Application for Approval of Details Reserved by Condition

Erection of residential development (55 dwellings) including access and associated infrastructure

2021/91871

RE: Hanging Heaton - Cycle Hoop (2021/91871)

PLANNING CONDITION 26 (2021/91871)

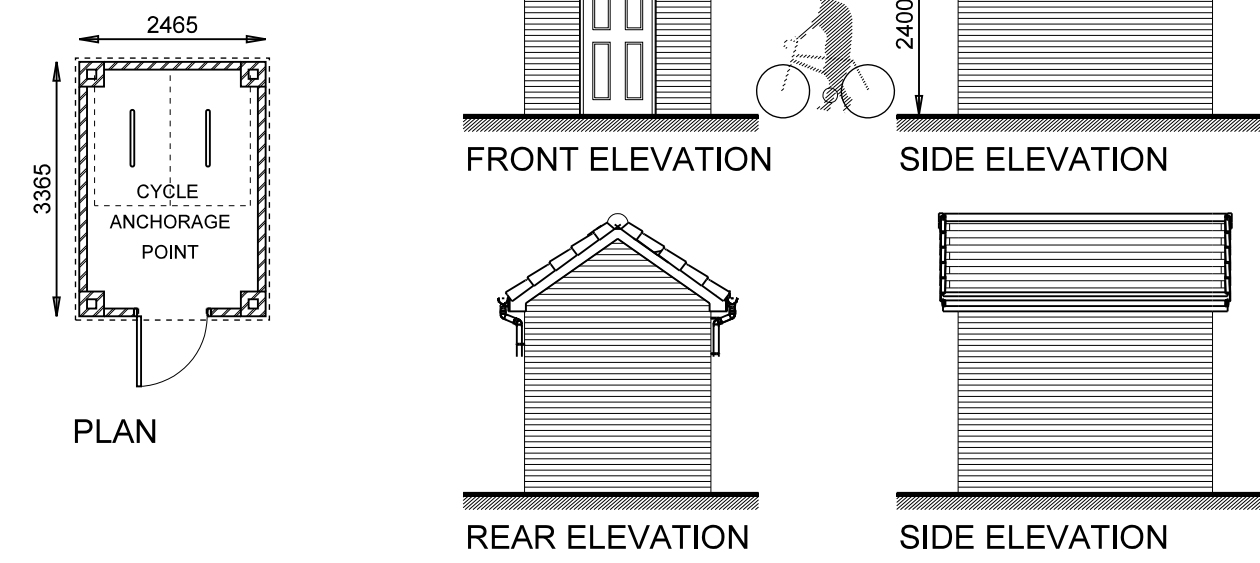
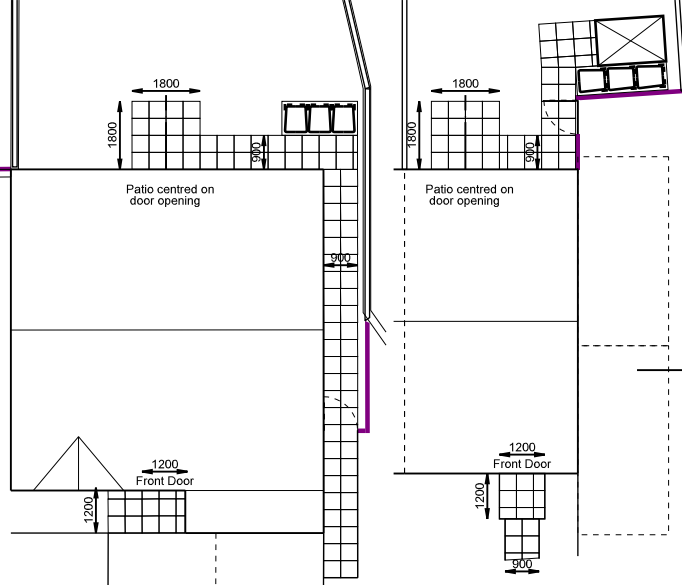
The footprint is fine, however I'd ask how wide the door is. It looks exceeding narrow (it may be the photo perspective) and could prevent handle bars going?

I'd need this clarifying, confirmation there would be no window, locations for each, and details on the security.
